July 2, 1996

Martin J. Chávez, Mayor  
Gregory J. Krenik, PE  
Mark Goodwin & Assoc.  
P.O. Box 90606  
Albuquerque, NM 87199

**RE: CIRCLE K - NUNZIO'S (C12-D3A). GRADING AND DRAINAGE PLAN  
SUBMITTAL FOR BUILDING AND SO #19 PERMIT APPROVALS. ENGINEER'S  
STAMP DATED 6-3-96.**

PROJECT TITLE	CIRCLE K
DRAWN BY	JMB
JOB NO.	96004
PROJECT MANAGER	C-K
SHEET TITLE	GRADING & DRAINAGE PLAN
START DATE	01/25/96
SCALE	1" = 30'
SHEET	C1

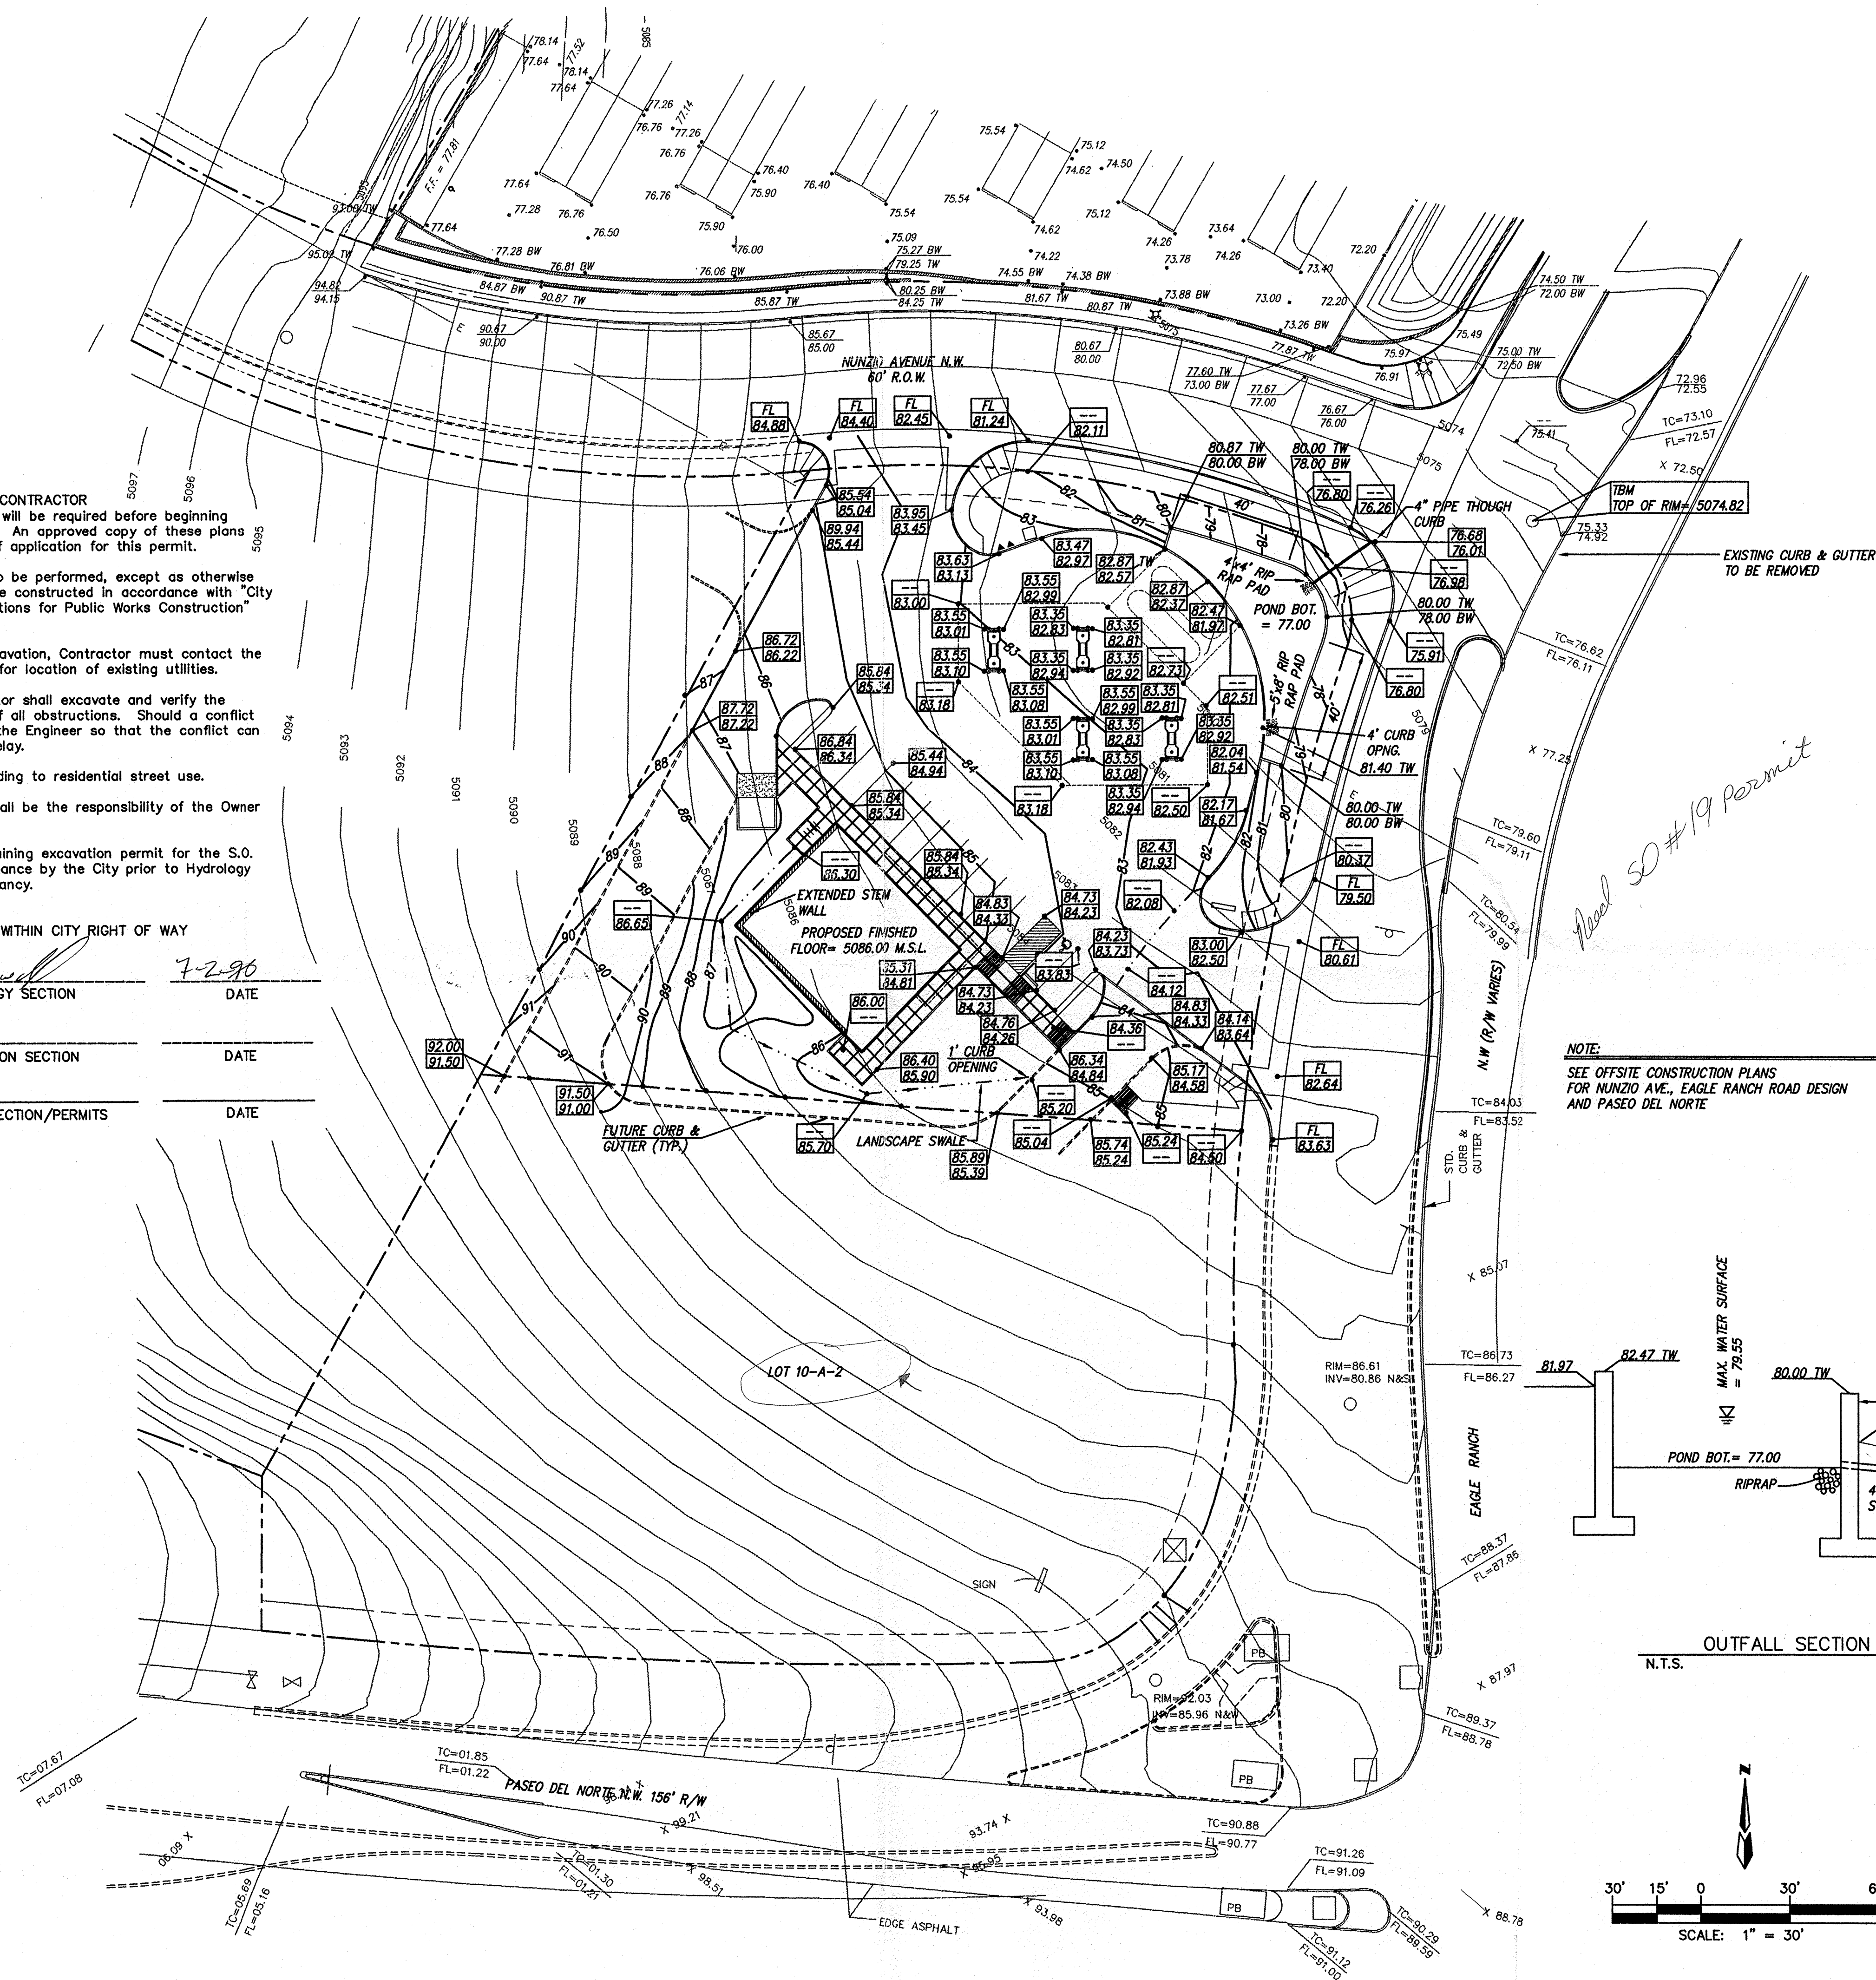
1. The detention basin should be lined with cobblestone or landscape rock for removal of floating oils/fuels.
2. The on-site manager should have a regular maintenance schedule for maintaining the detention basin area.
3. The City suggests that the area around the fueling bays and under the canopy be graded so that in the future, the fueling area can be contained and all washdown water collected and routed to an oil/water separator. This separator would be connected directly to the sanitary sewer, not to the storm drain. The City is currently modifying requirements for fueling areas, and the above requirement for containment of washdown areas and canopy areas may become standard.
